Subject: FW: Consultation response

**From:** Oliver Waring  
**Sent:** 28 November 2017 16:59  
**To:** David Elmore <d.elmore@welhat.gov.uk>  
**Subject:** RE: Consultation response

Drawing title	Status, Drawing number & revision	Amendments
Proposed Site Plan	3280/ 030 M	Planning - Material Amendments
Drawn by	Checked by	A1 Scale
EM	JA	As indicated
		A3 Scale
		Date
		14/06/2018
		14:31:20
		Status
		PLANNING

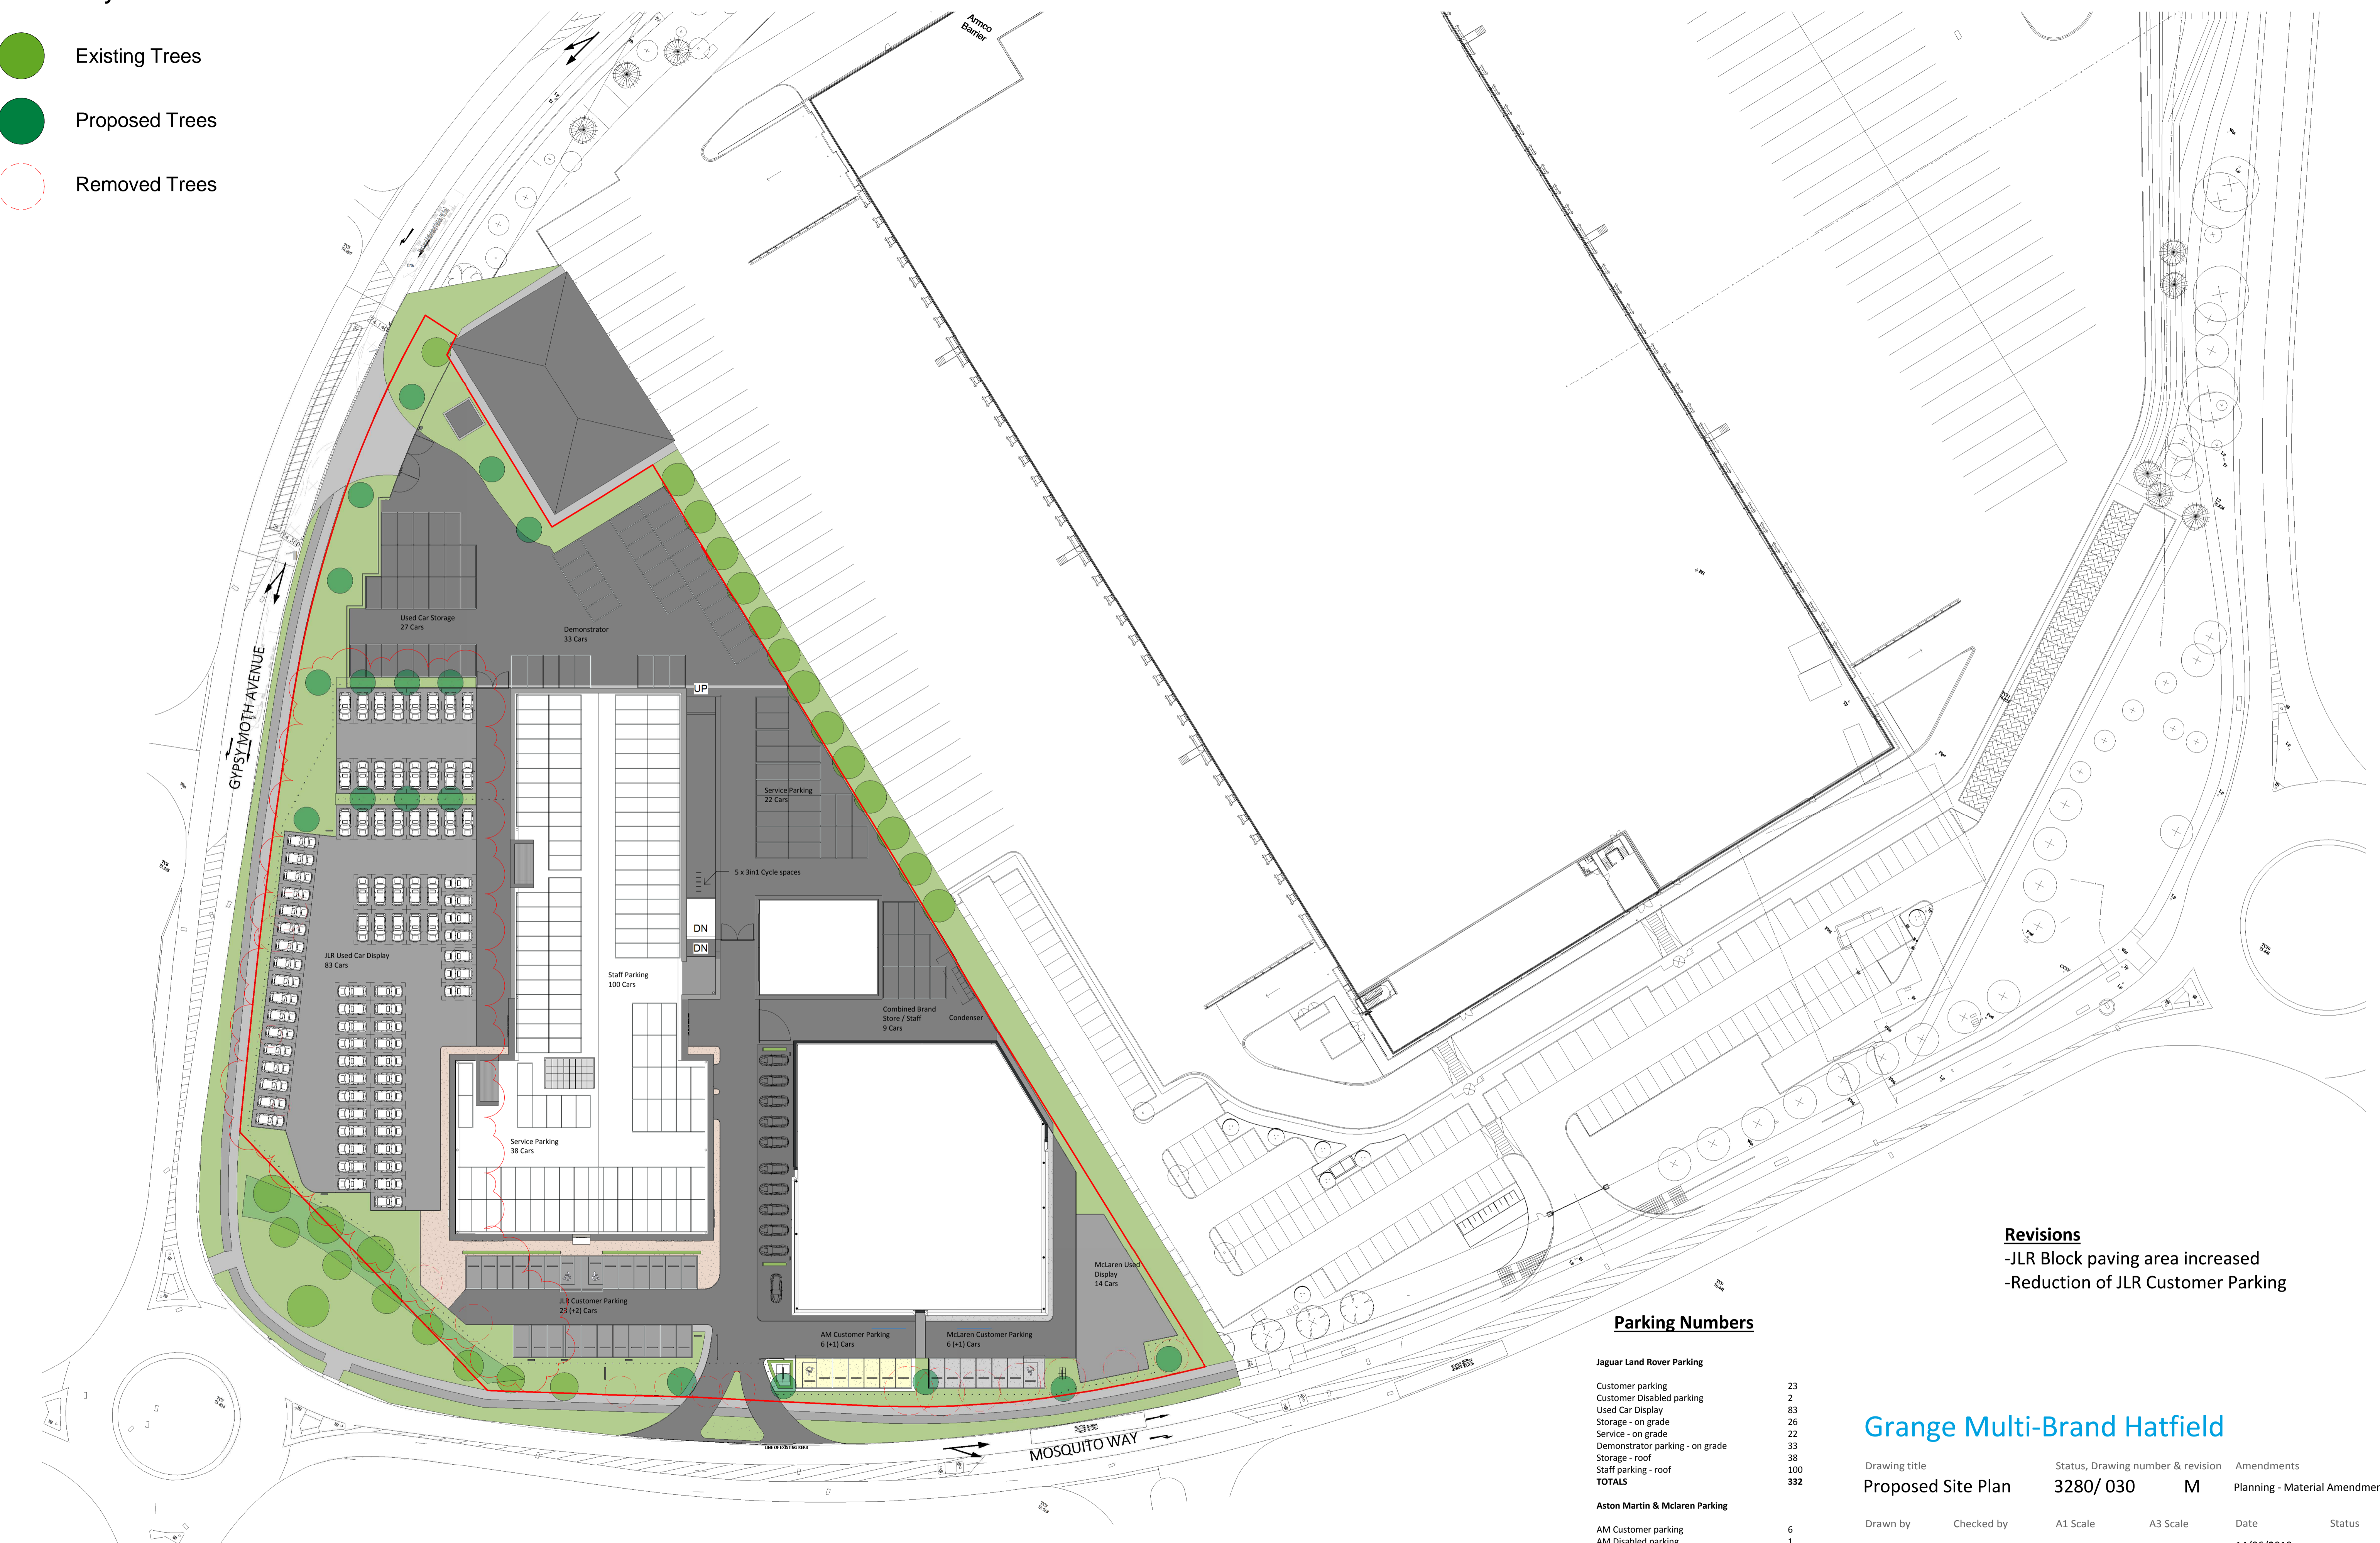
I have taken a look at the plans supplied. In principle the scheme is sufficient, however further details is required:

- A tree protection plan and method statement to ensure the retained trees are protected throughout the development. These should be in accordance with BS: 5837: 2012
- Details of plants and trees used (some details have been supplied but not all). Species, size and planting densities.
- Planting methods and aftercare including watering.
- A condition that any plants that fail within the first five years are replaced.
